Reference: Engineering Services  
49 Alice Holleman Lane  
Fuquay-Varina, NC 27526  
TE&D Project No.: 2201-020668

- 1) Analysis of (3) 2 x 12 beam installed within the Basement of the rear addition.

Floor System layout

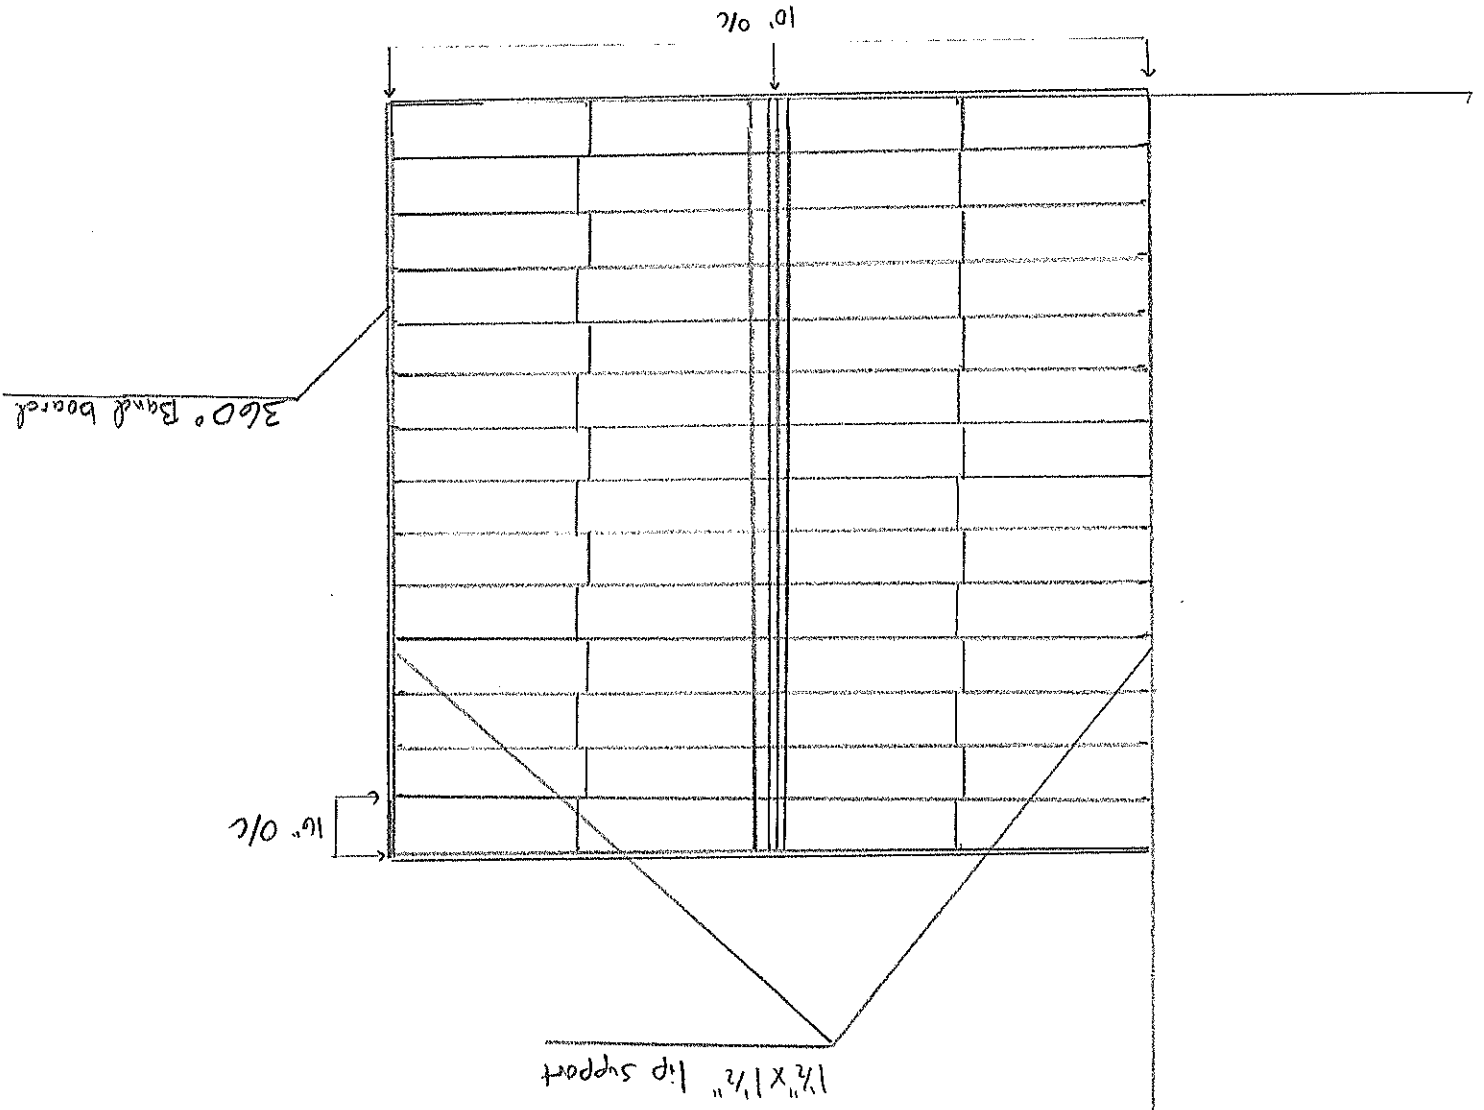
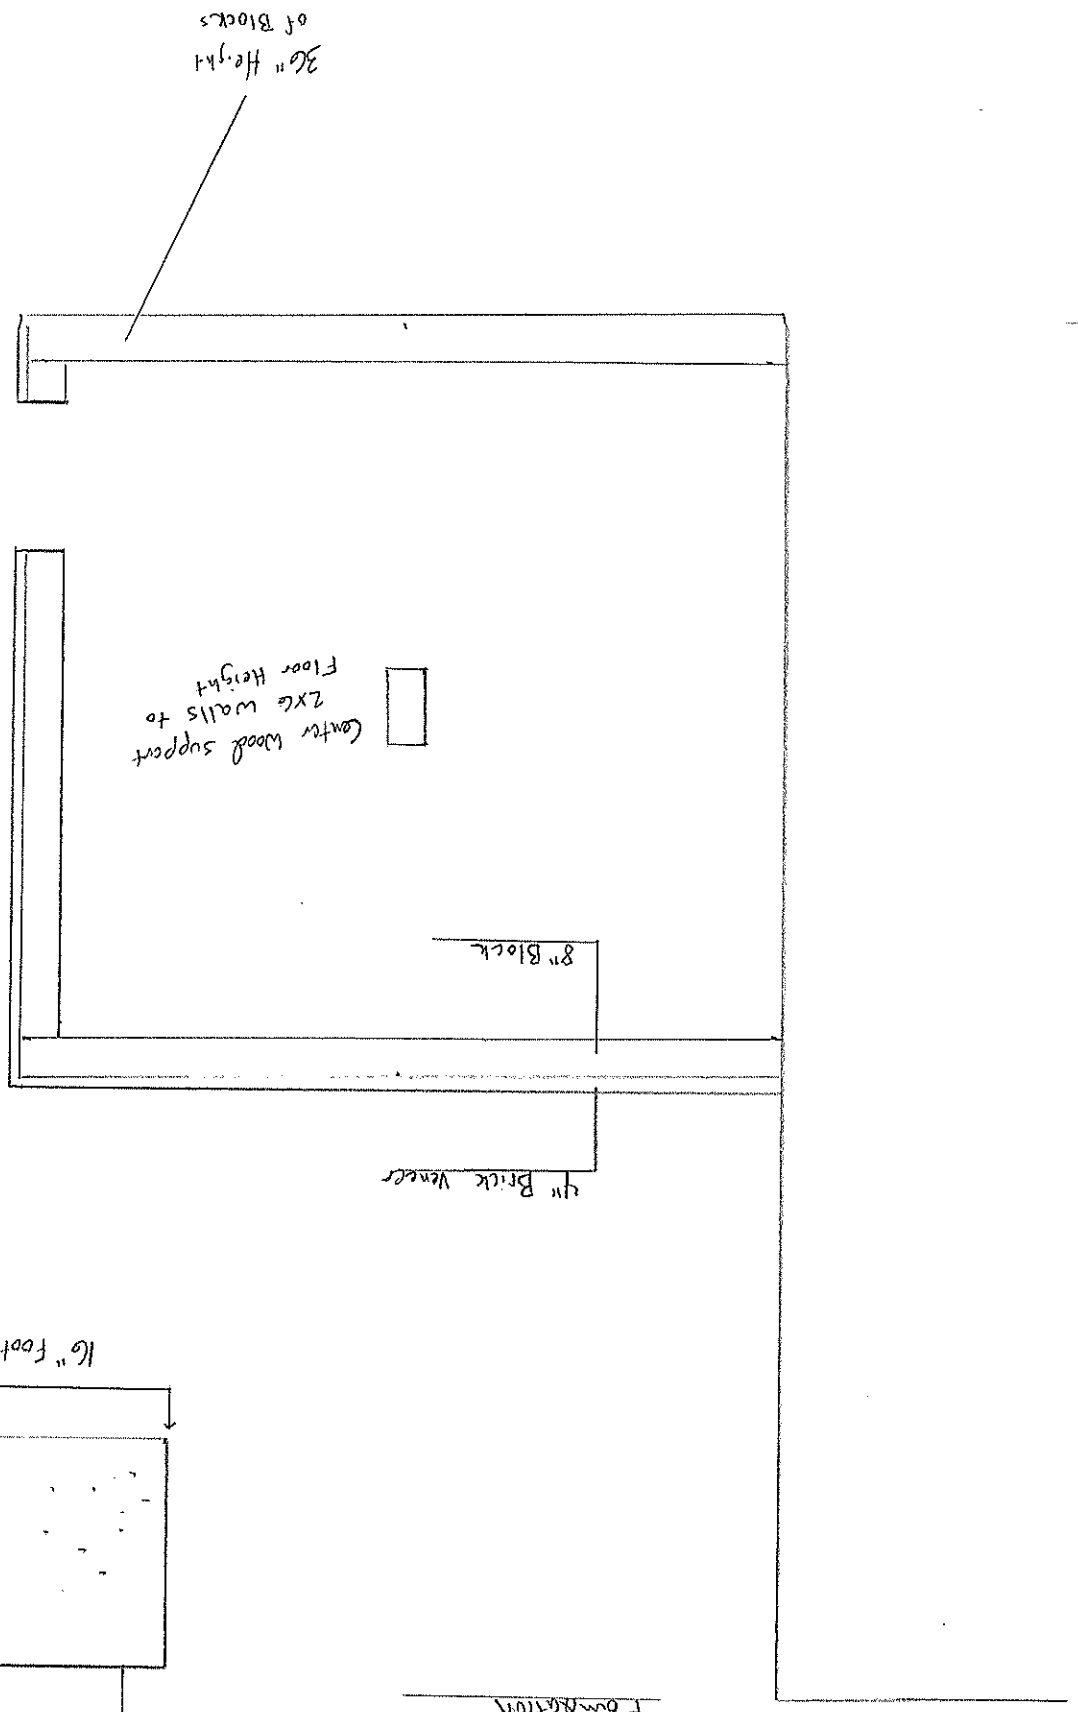
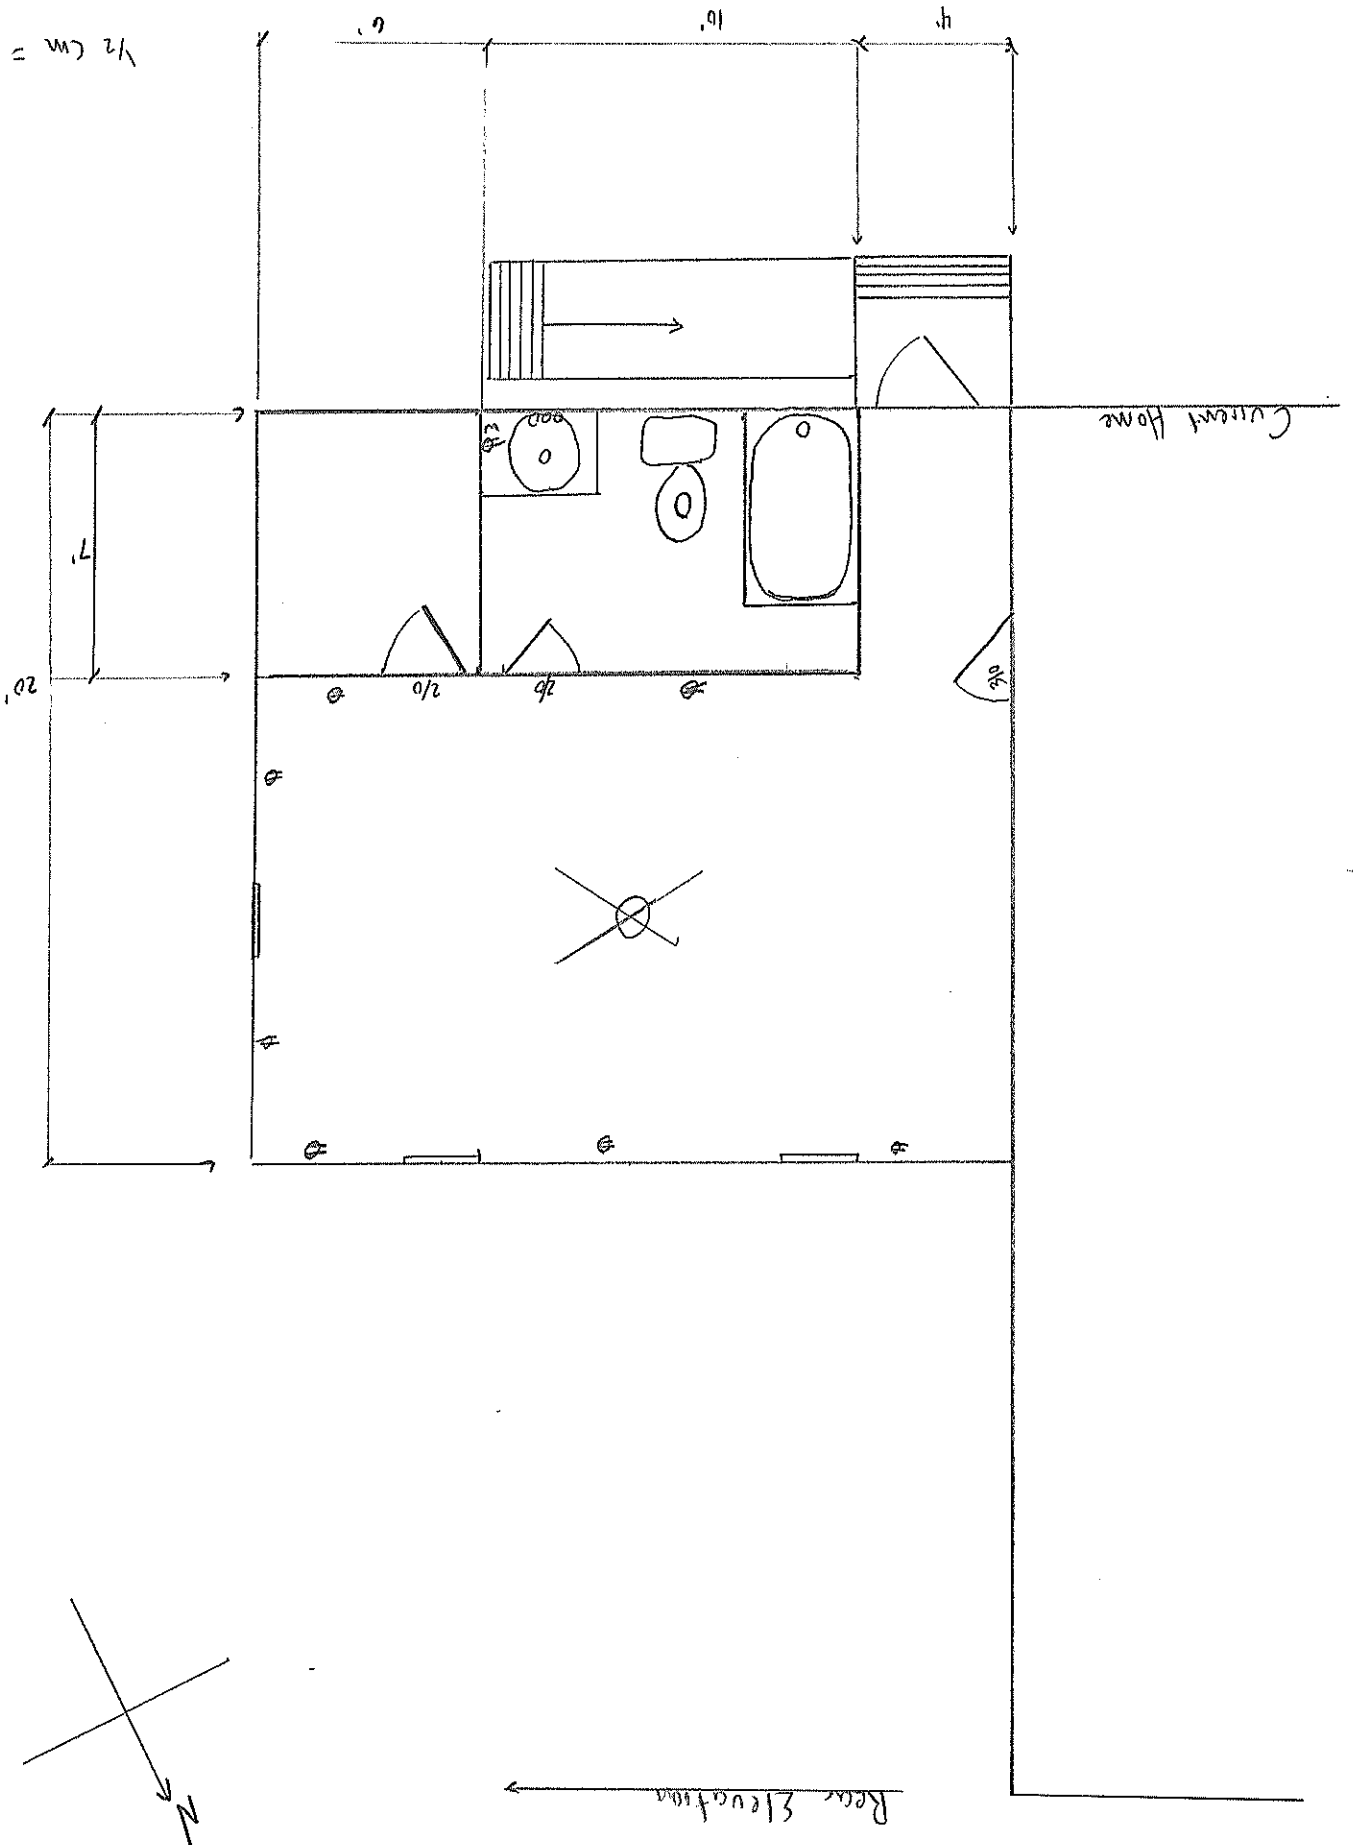
- 1) We observed a (3) 2 x 12 girder had been installed spanning left to right. The beam was supported by (3) 2 x 8 stud columns at each end. The beam was also supported at the mid-point by a steel jack on an approximately 24" x 24" concrete footing. The depth of this footing could not be verified due to the existing slab surrounding it. Based on our analysis of the existing and anticipated loading conditions, this footing is to be verified to be a minimum of 10" thick.

The existing (2) 1/2" through bolts installed at each end of the splice are suitable. Upon completion of the footing verification, the (3) 2 x 12 beam and its current configuration will be adequate to support the anticipated loading conditions.
